**From:** Jonathan Emanuel <jonathan.emanuel@cherwell-dc.gov.uk>  
**Sent:** 22 December 2022 10:16  
**To:** Planning <Planning@Cherwell-DC.gov.uk>  
**Cc:** Andy Bateson <Andy.Bateson@cherwell-dc.gov.uk>  
**Subject:** RE: Planning notification for application reference: 22/03452/F

Before I can make an informed comment, the Arboricultural Report contains some anomalies and need to be confirmed. The schedule states that G4 which appears to consist of 10 Cat B trees is to be removed to facilitate the development, and yet the AIP & TPP shows the tree group is to retained and protected. If the trees are retained then the AIA/MS needs to provide details as to the construction method within the RPA.

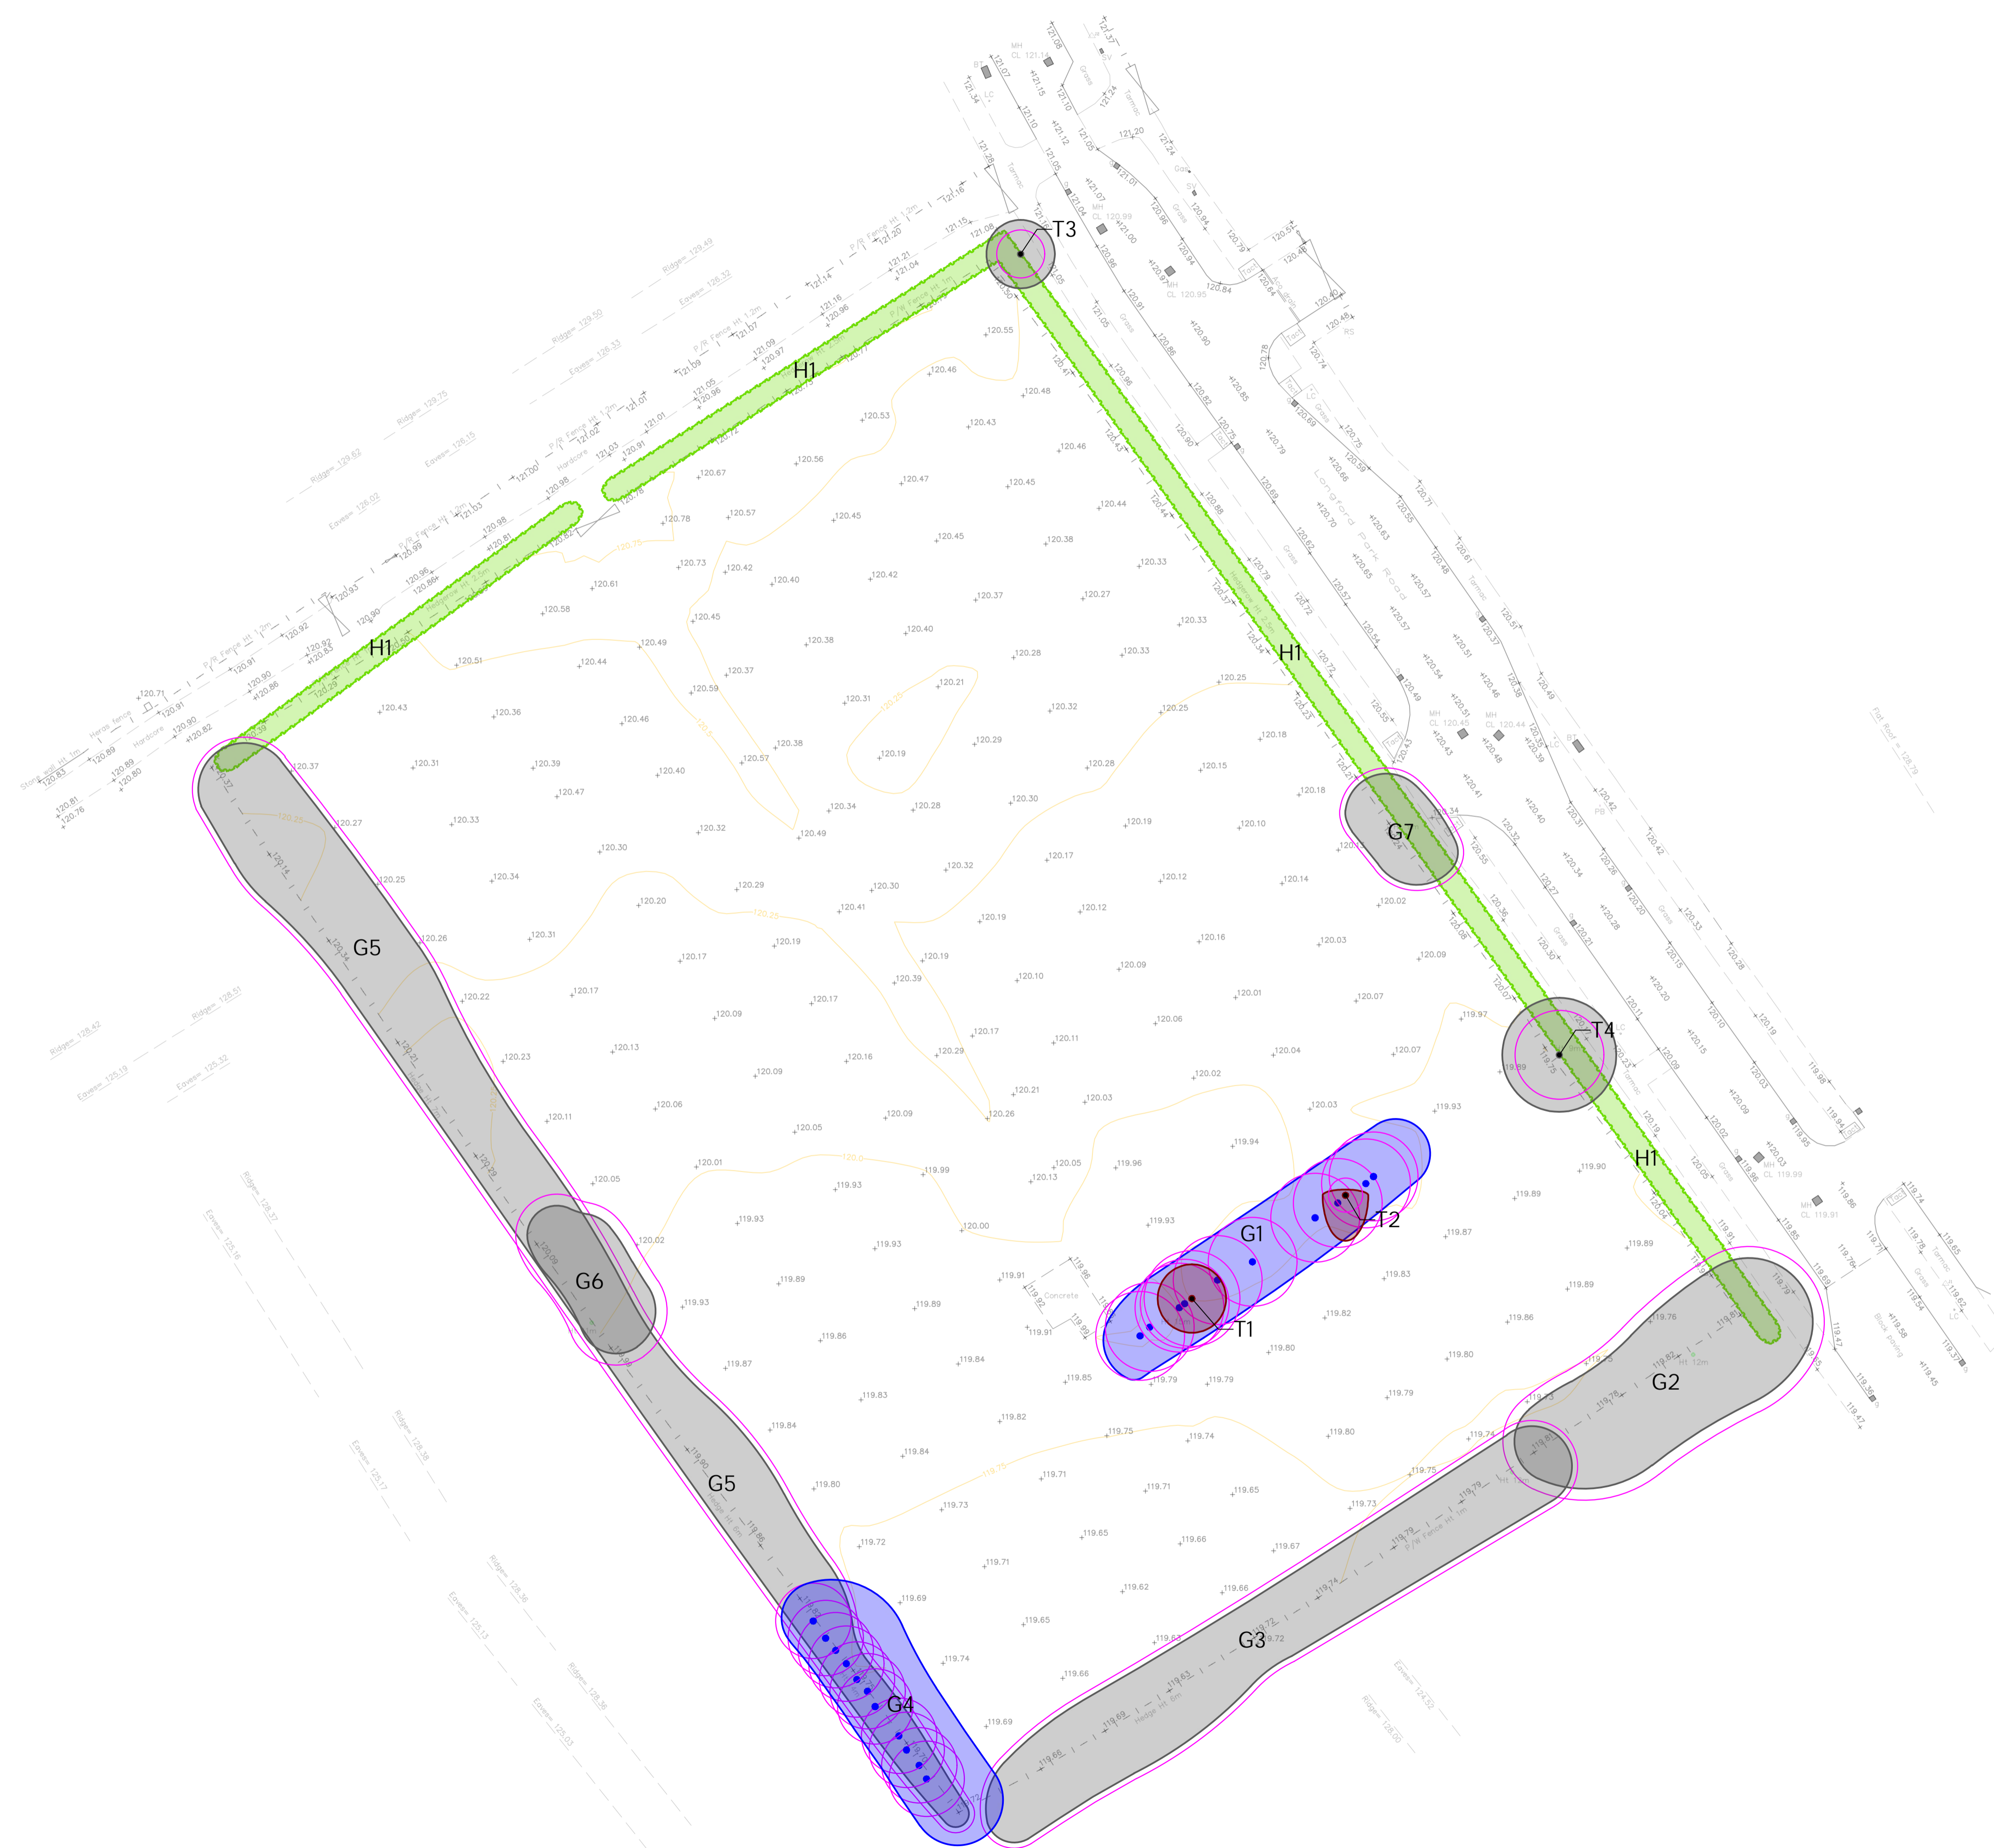
The snip below shows x2 additional trees with no specific reference that have not been identified within the schedule.
